Application for a non-material amendment following a grant of planning permission. Town and Country Planning Act 1990

Unit:		House number:		House suffix:	
House name:	GOOD HEYS FARM				
Address 1:	UP BGD LAM ROAD				
Address 2:					
Address 3:					
Town:	THORNLEY WITH WHEATLEY				
County:					
Postcode (optional):	PR3 2TL				
Description of location or a grid reference. (must be completed if postcode is not known):					
Easting:		Northings:			
Description:

PROPOSED HYDROTHERAPY POOL EXTENSION AND LINK EXTENSION BETWEEN EXISTING BUILDINGS.

SUBSTITUTION OF EXISTING TIMBER WINDOWS TO NEW HERITAGE PVC U WINDOWS - STYLE TO MATCH.

Drawing
PROPOSED SCHEME

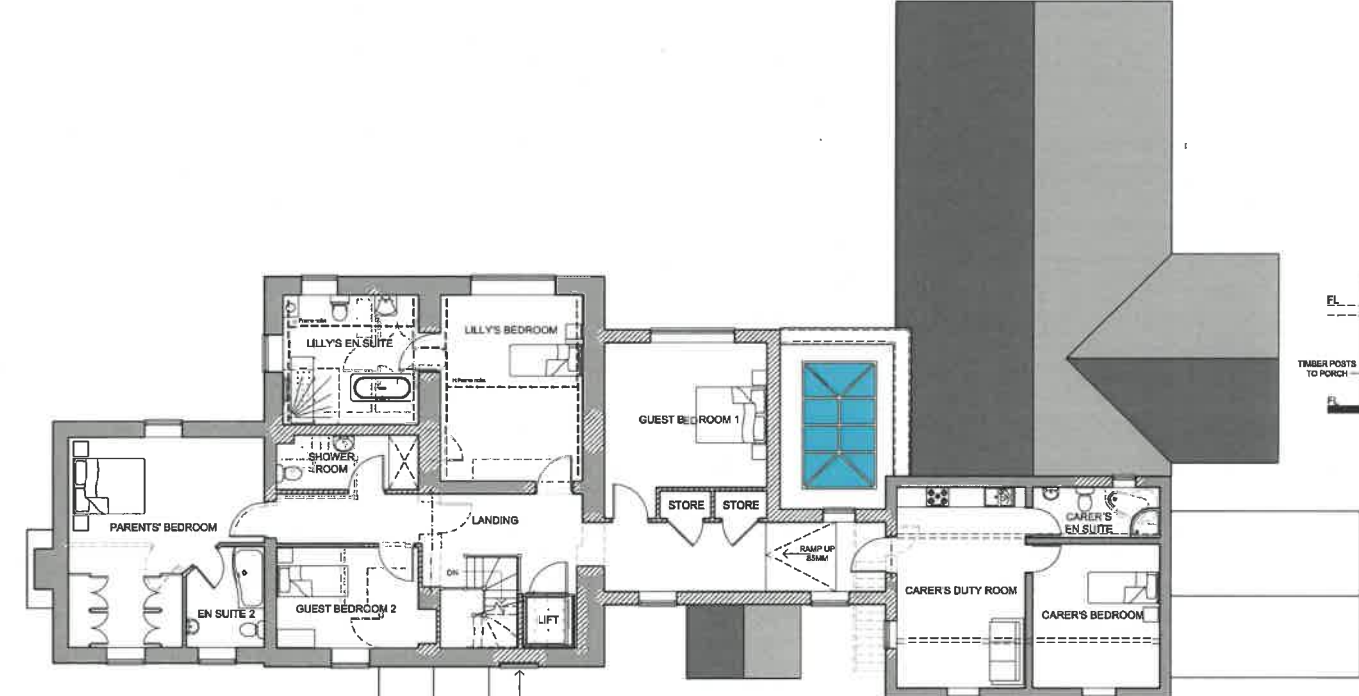
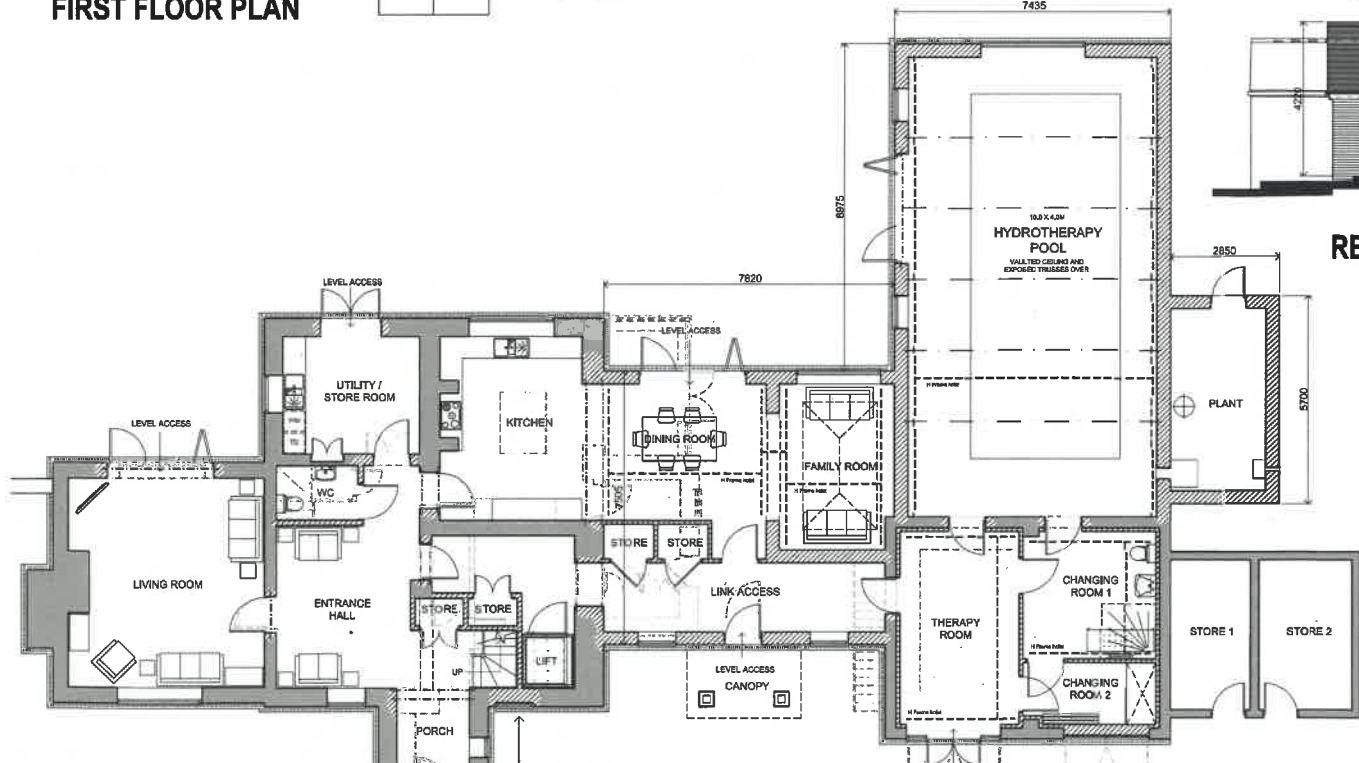
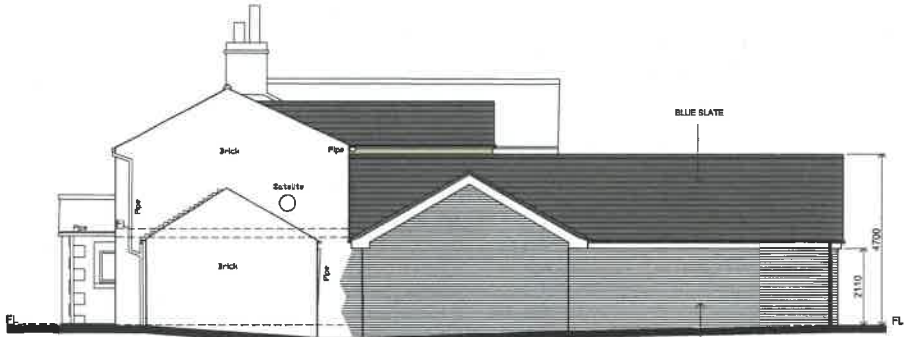
Old plan/drawing number(s):

14964A (CH) 02 D

New plan/drawing number(s):

14964A (CH) 02 E

EXISTING WINDOWS ARE IN A POOR CONDITION. PVCU WINDOWS WILL BENEFIT OUR DISABLED CLIENT IN THAT THEY WILL BE MAINTENANCE FREE AND THEY WILL ALSO ASSIST IN REDUCING ENERGY LOSS AND HEATING COSTS.
